From: Simon Davis
Sent: 01 May 2019 17:15
To: [REDACTED]
Subject: AL/27/19/DOC - GTR DENMANS LANE FONTWELL

I am chasing a consultation response on AL/27/19/DOC which seeks the discharge of condition 08 *"Piling or any other foundation designs using penetrative methods shall not be permitted other than with the express written consent of the Local Planning Authority, which will only be given for those parts of the site where it has been demonstrated that there is no resultant unacceptable risk to controlled waters."*

FOUNDATION NOTES :-

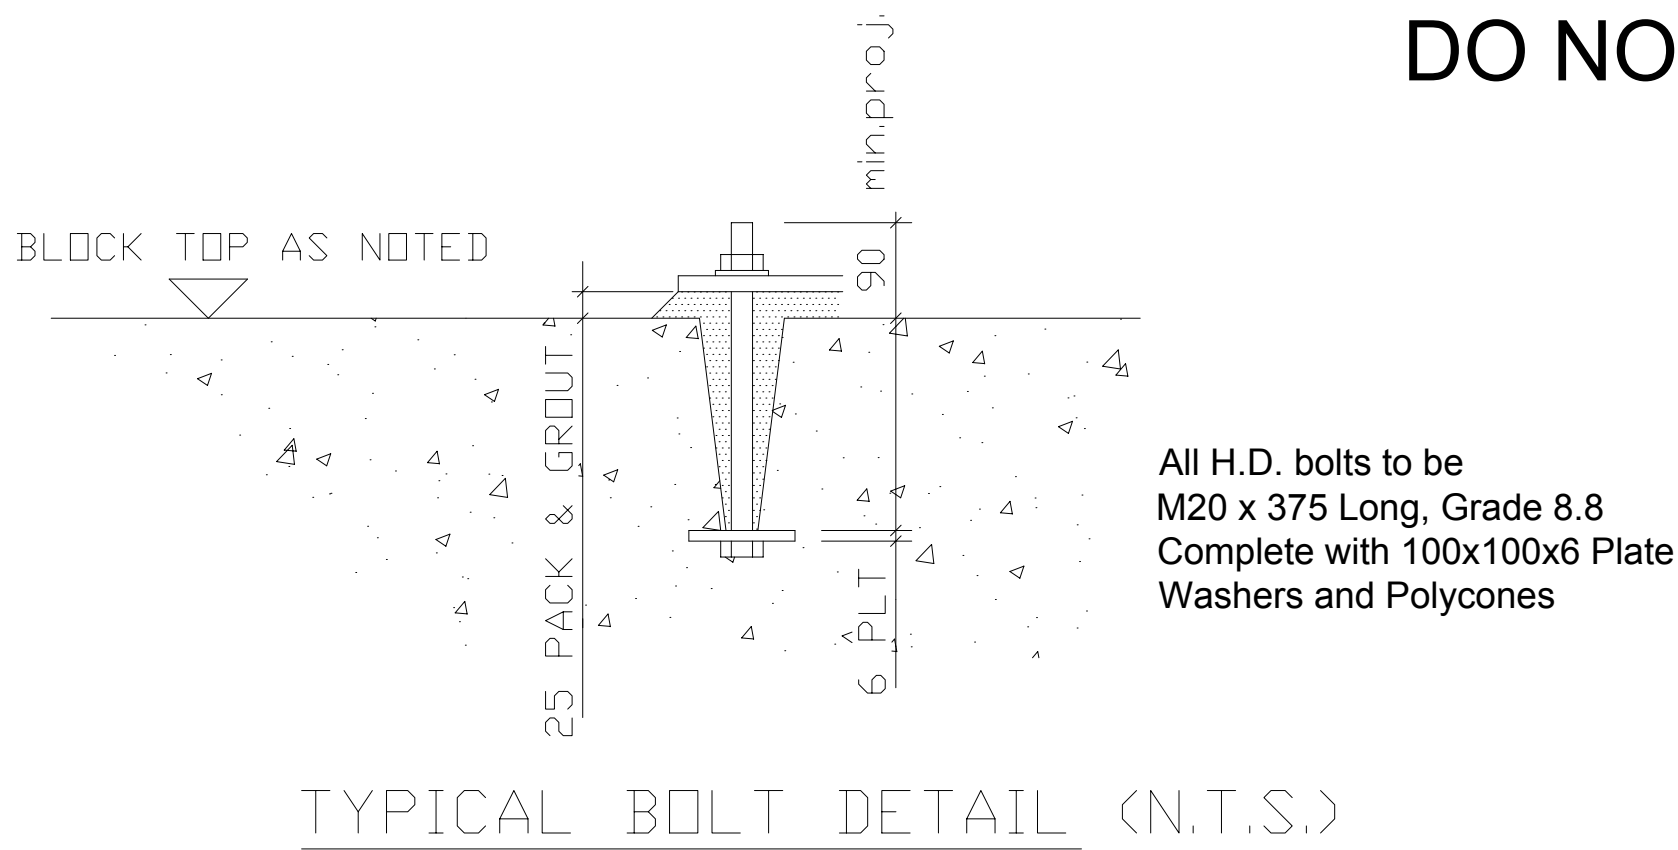
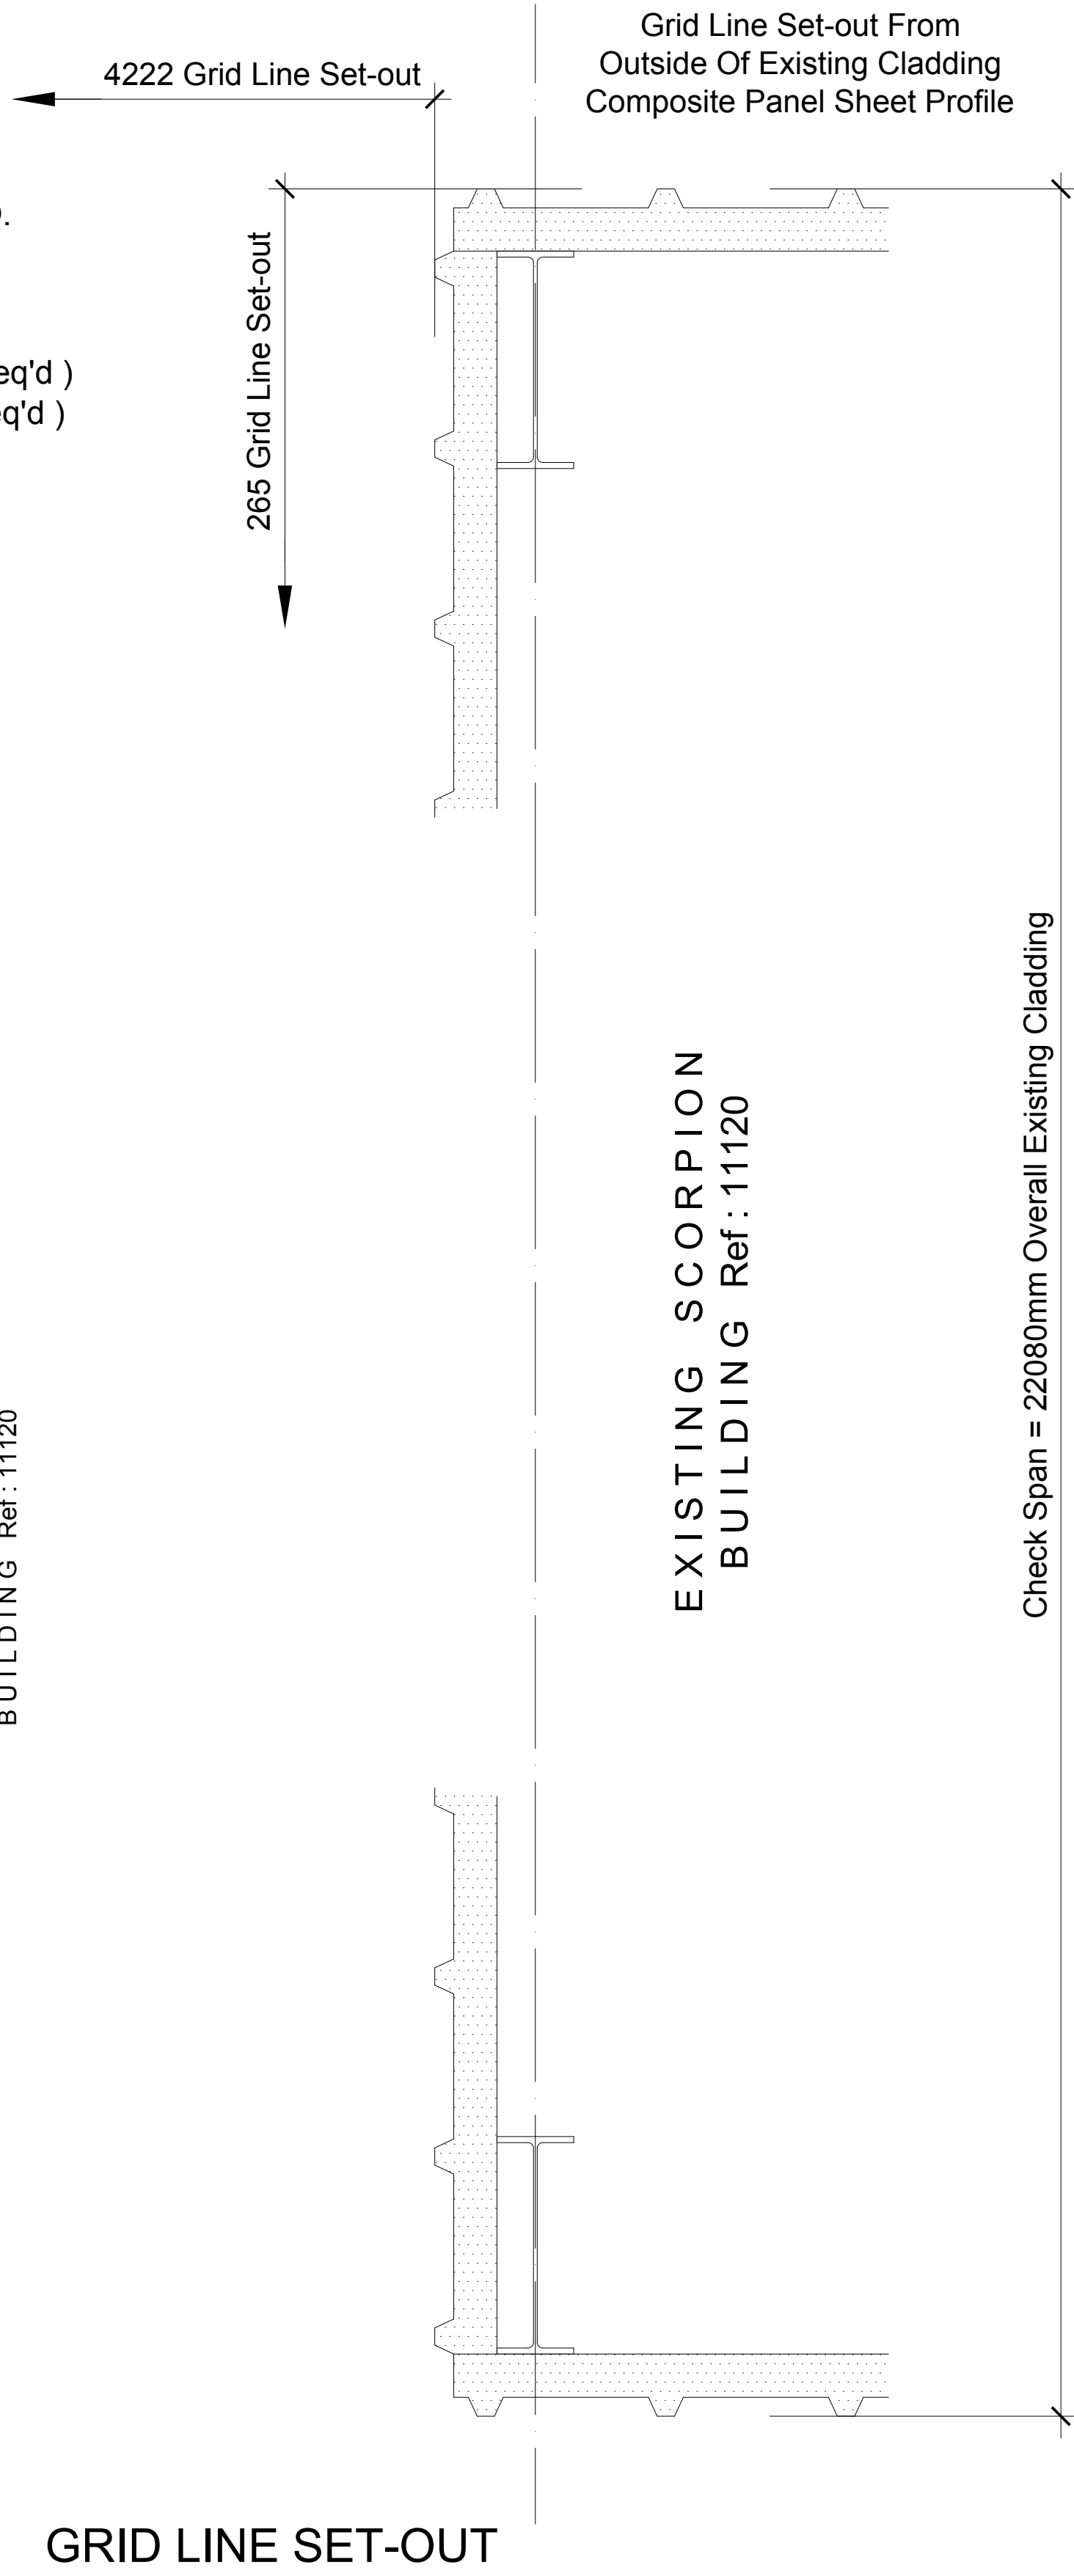
The application states that although piling is not used they will be using concrete blocks to a max depth of 1.75m. Having discussed with Building Control officers here, I consider that this is a penetrative method hence the need to gain approval. Can you therefore advise whether you are in agreement with this? There are additional details of the foundations in the plans available on our website
